Submission: 27-29 Tryon Road, Lindfield NSW 2070

State Significant Development

I am writing in relation to the proposed State Significant Development application SSD-78669234 – Residential flat building with in-fill affordable housing – 27-29 Tryon Road, Lindfield. This building falls within the LGA I reside in, and I request that the concerns in this submission alongside other similar submissions will be considered and addressed to ensure a more than optimal outcome for the local community and the environment.

Figure 14 Proposed Level 4-6 Plan showing setbacks (Source: PTW)

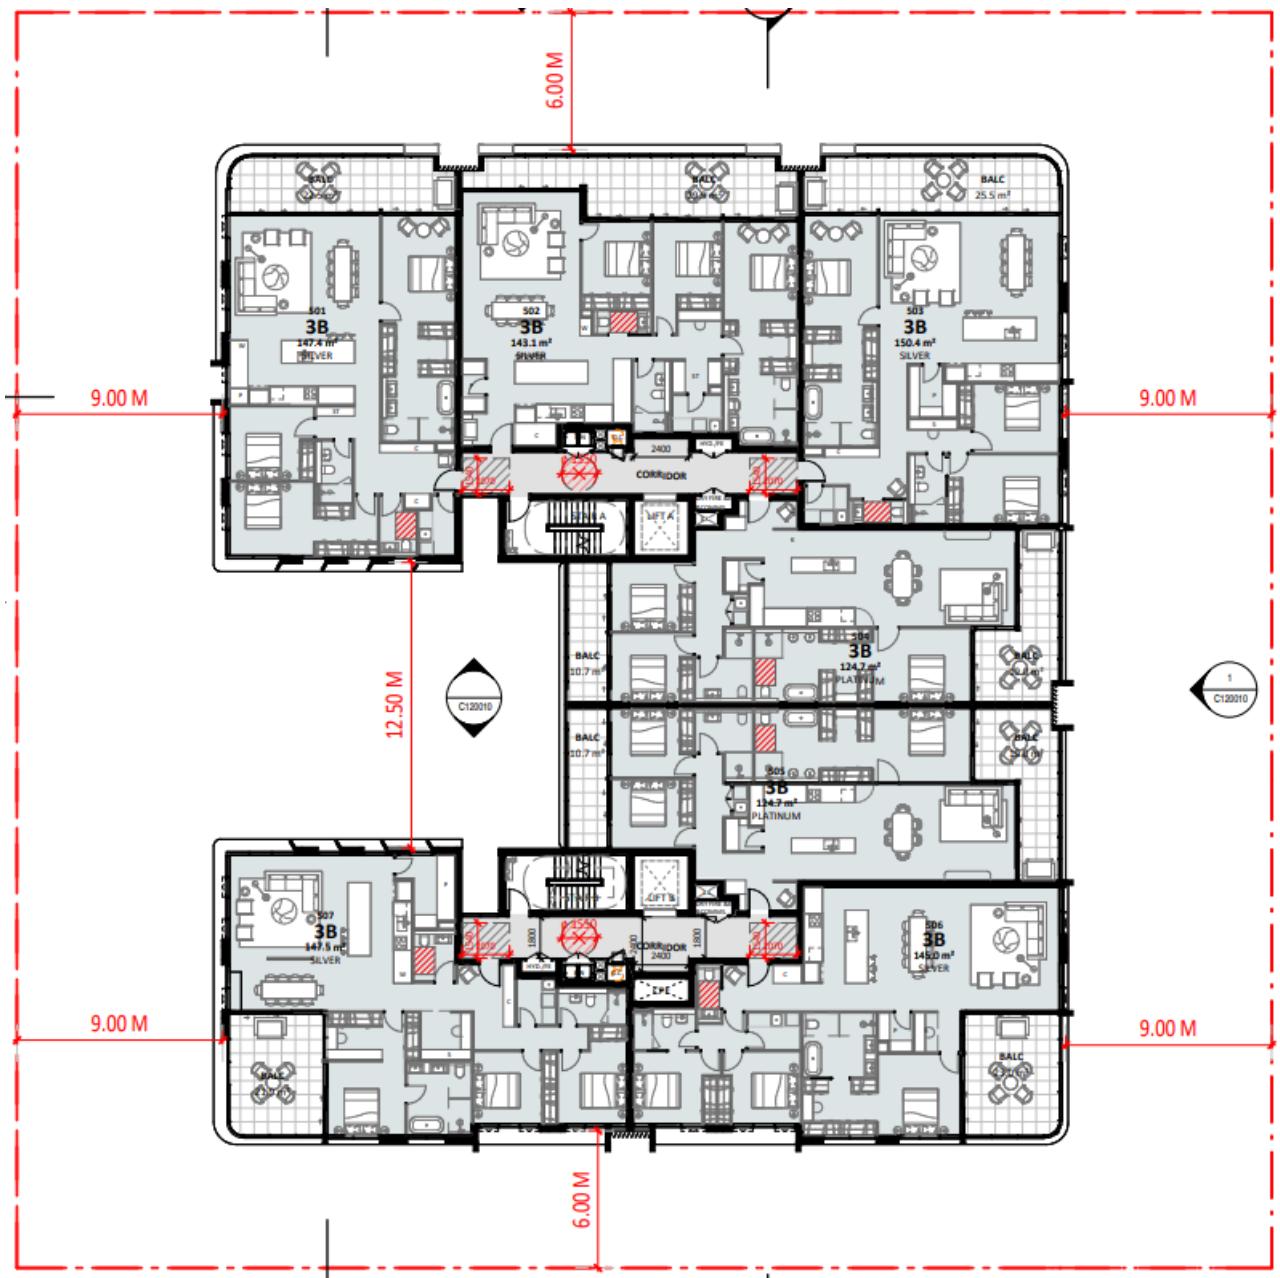
The 6m front setback and the 3m side setbacks are less than optimal for a building this size. In Ku-ring-gai Council, residential flat buildings constructed in the past have adhered to the minimum 10m front setback and 6-9m side setbacks stated on the KDCP. This practice allows increased deep soil, tree canopy cover, and vegetation to surround the building, encouraging the important environmental benefits stated in the above point, alongside providing residents with optimal views to nature and increased privacy. Additionally, the generous front setback allows the uniquely high-density building in the lower-density surrounding environment to share a similar character alongside older development or previous residential flat buildings regulated by the KDCP. This includes the tall, large trees and the open, blue sky associated with Ku-ring-gai.

However, the current proposed setbacks do not facilitate any of these benefits or qualities. The 6m setback may align similarly with adjacent developments, but at 9 storeys the proposed building is significantly taller than its 5 and 3 storey neighbours. Neither of these developments are likely to be upzoned, demolished, and rebuilt for many years due to financial viability and costs. The justification provided for the 3m side setbacks is that the responsibility of maintaining adequate building separation required by the NSW Apartment Design Guide should be passed to the future development, and that the future adjacent building must increase their setback to accommodate for this. This justification is questionable as it unfairly impacts adjacent sites.

- Increase the front setback from 6 to 10m to allow for increased deep soil and to maintain the surrounding character for the reasons provided above. If the rare instance that 10m is deemed to be completely unfeasible, please increase the setback as much as possible to the target distance.
- Increase the side setback enough to ensure adjacent sites will not be required to increase the setback of future buildings more than the minimum requirements.
- Increase the building height from 9 storeys to accommodate for the loss in floor area due to the additional setbacks. This may result in a building height of 10-12 storeys.

Figure 15 Proposed basement plan showing setbacks (Source: PTW)

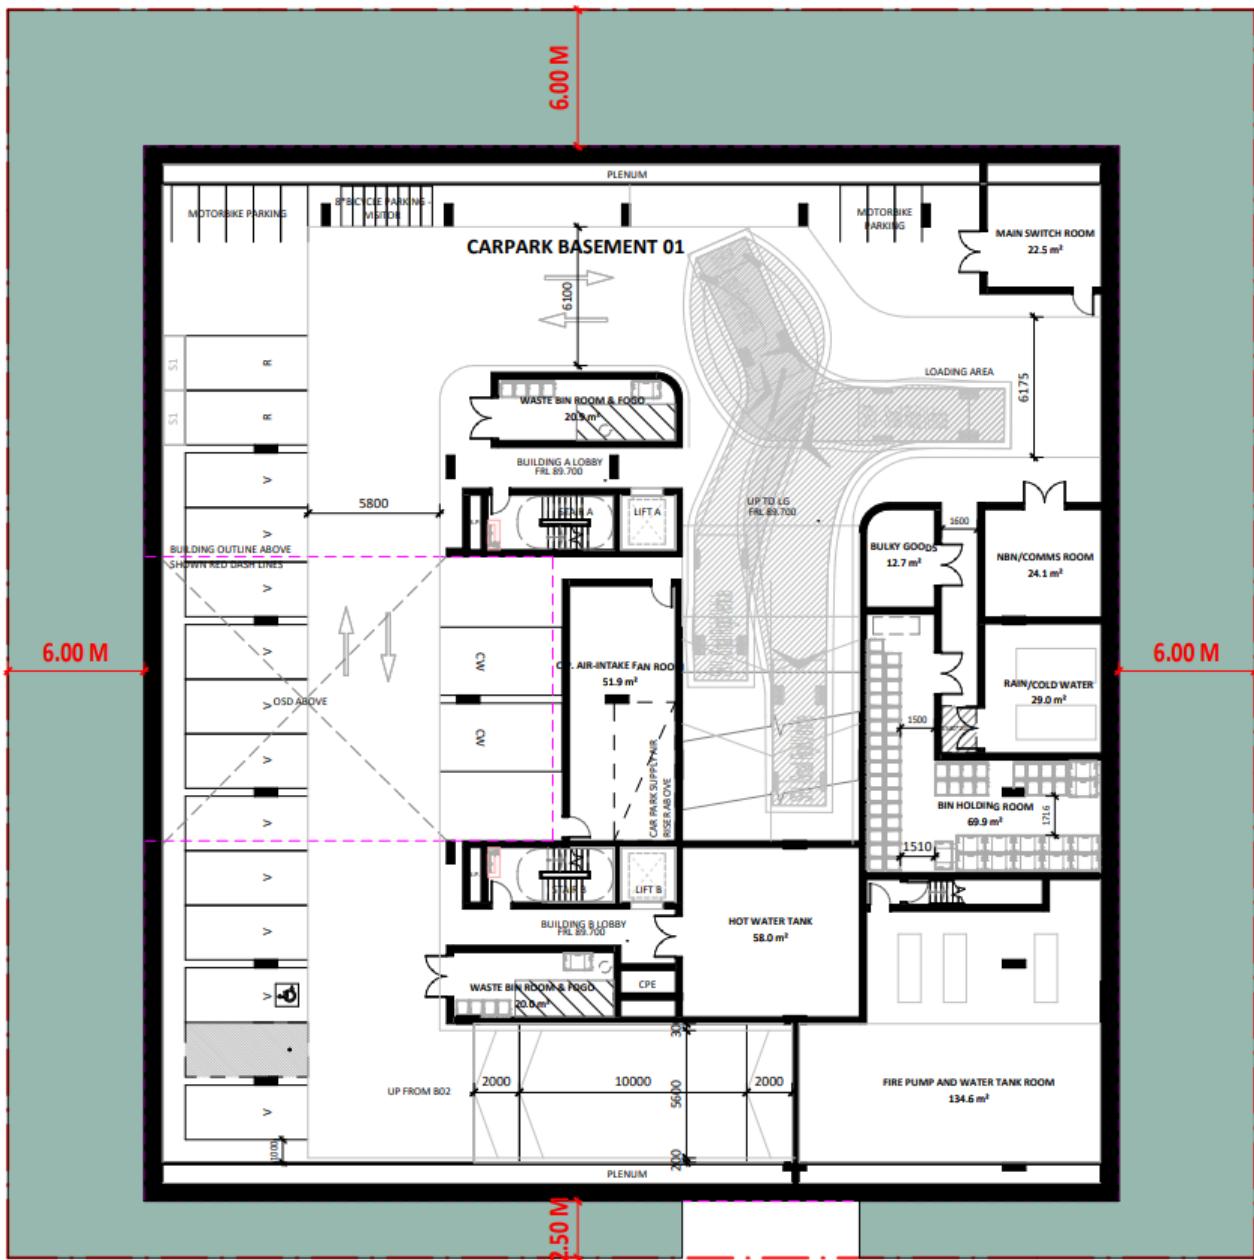
The most significant factors reducing the amount of deep soil proposed are the narrow setbacks due to the large footprint of the basement. For this site, the KDCP has been used to justify the high number of parking spaces – 123 spaces for 62 dwellings. On average, this is almost two spaces per dwelling, and has resulting in a inefficient four-level basement with two different footprints. Additionally, tandem parking is an inefficient layout that increases the number of parking spaces and the footprint of the basement, for minimal advantage. This provides limited deep soil opportunities throughout the site, negatively impacting the surrounding environment. In conjunction with potential risk for increase car usage and congestion, this plan must be revised to ensure that the development maintains a low ecological impact.

The inefficient and large basement with two different footprints results in limited space for deep soil. Additionally, tandem parking is an inefficient layout that increases the number of parking spaces and the footprint of the basement, for minimal advantage. It is unknown why the deep soil percentage stated on the image is not consistent with other figures.

- Rearrange the basement of the building to reduce its footprint. This may require reducing the number of parking spaces to achieve this or constructing an additional level below.
